HINCKLEY NATIONAL RAIL FREIGHT INTERCHANGE

Project reference TR050007

Applicant's response to deadline 3 submissions [Part 7 - Statutory Bodies]

Document reference: 18.13

## Link ID - Sheet 11

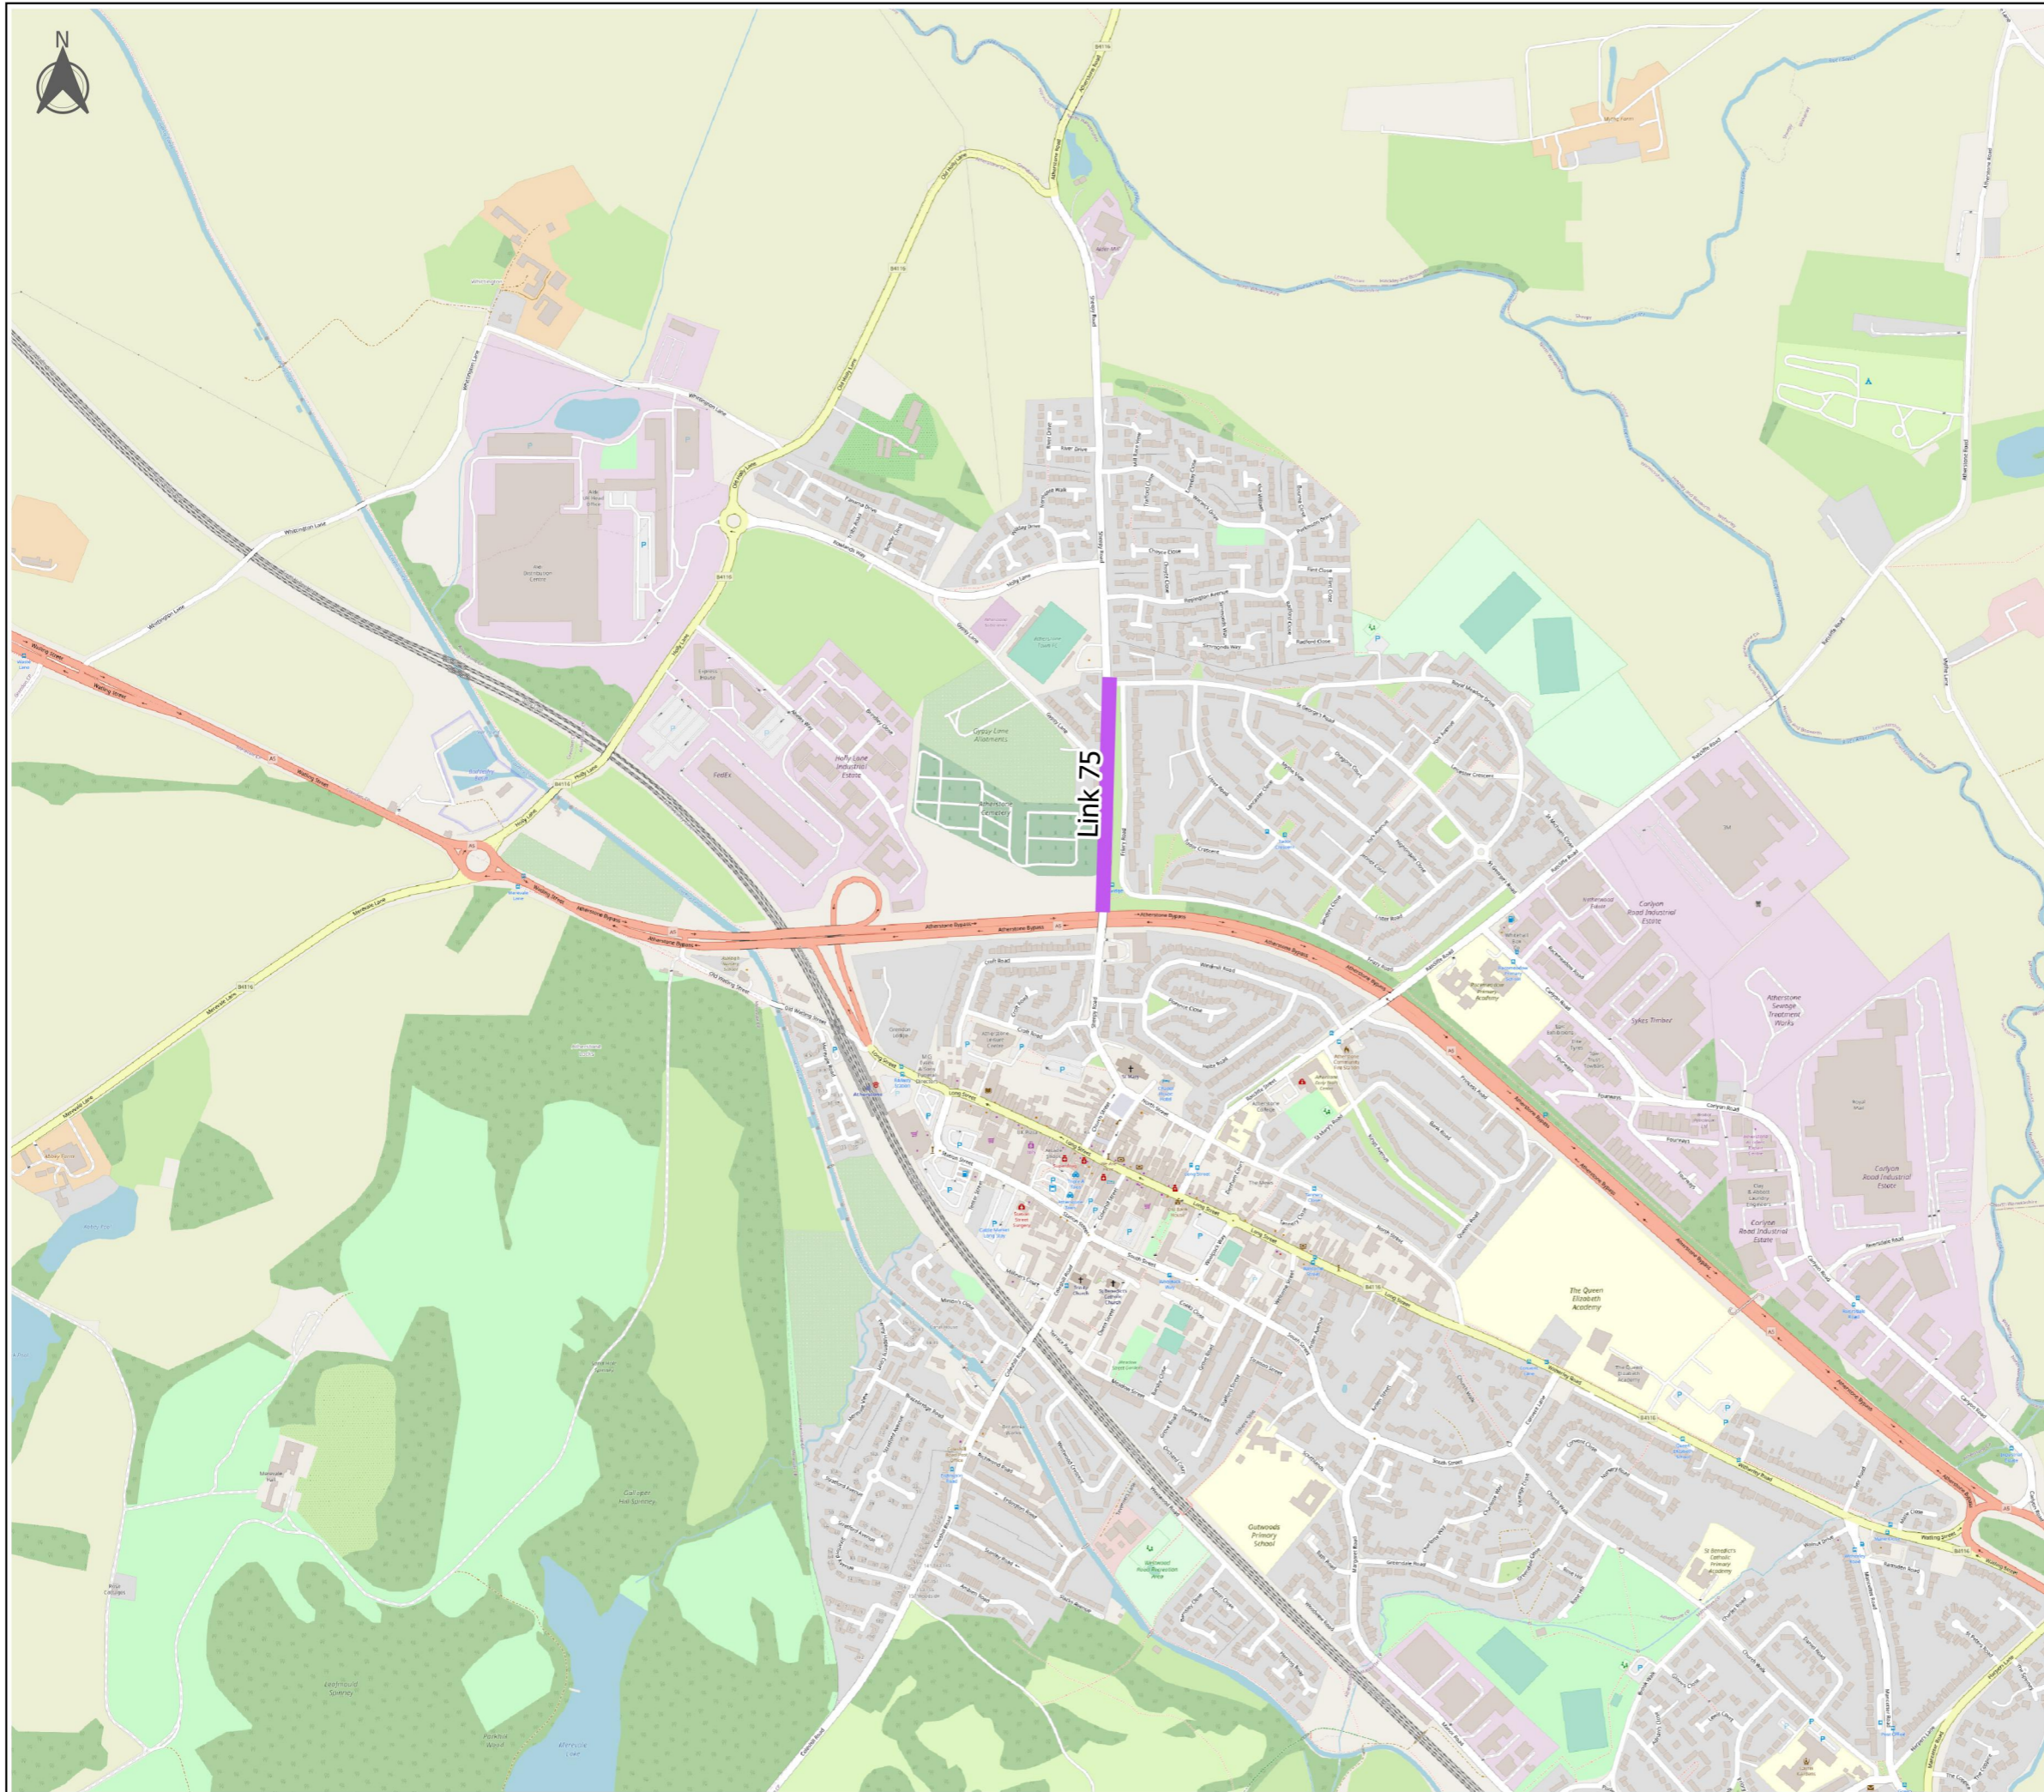
51	<p>2.2.4 In our view some of these modelled outputs are not entirely credible, particularly with regards to HGVs. For example, if one considers link 42 and 87, both on Stanton Lane (Link Table 21), the number of HGVs on link 87 in the ‘without development’ case is significantly higher than 42 (110 compared to 87) but there is no obvious reason for this. In the development case both still increase but that HGV difference reduces, (noting, of course, that there is no figure to say if that number would increase following mitigation at the B4669/Stanton Lane Junction)</p>	<p>Further information was provided in an HGV impact note at Deadline 3 (document reference: 18.6.6, REP3-051). This discusses impacts around the eastern villages as well as other sensitive locations, in relation to redistribution of HGVs and availability of routes to the Strategic Road Network.</p> <p>However, in answer to this query re links 42 and 87 on Stanton Lane, BWB received AADT PRTM flows from AECOM, acting as the Modelling consultant for LCC NDI. It is understood that AECOM determined the AADT flows by commissioning various ATC points situated on roads of different classifications. They then calculated a percentage increase in flows between peak hours and AADT flows for each road classification. The road classifications provided by AECOM are as follows:</p> <ol style="list-style-type: none"> 1. A Road 2. B Road 3. TRADS (Motorways) 4. Unclassified Roads (Rural) 5. Fixed (Residential) <p>A review of the PRTM link network indicates that the road classification changes from 2 to 5 between Link 42 and Link 87, respectively. Consequently, it is understood that factors respective of the road classifications were applied to each link to calculate the AADT link flows, and therefore presenting a difference in flows. Both links have been assessed in the ES Chapter and as shown above the larger HGV impact is assessed in the area that would have the most impact (northern end of Stanton Lane) as a worst case.</p>
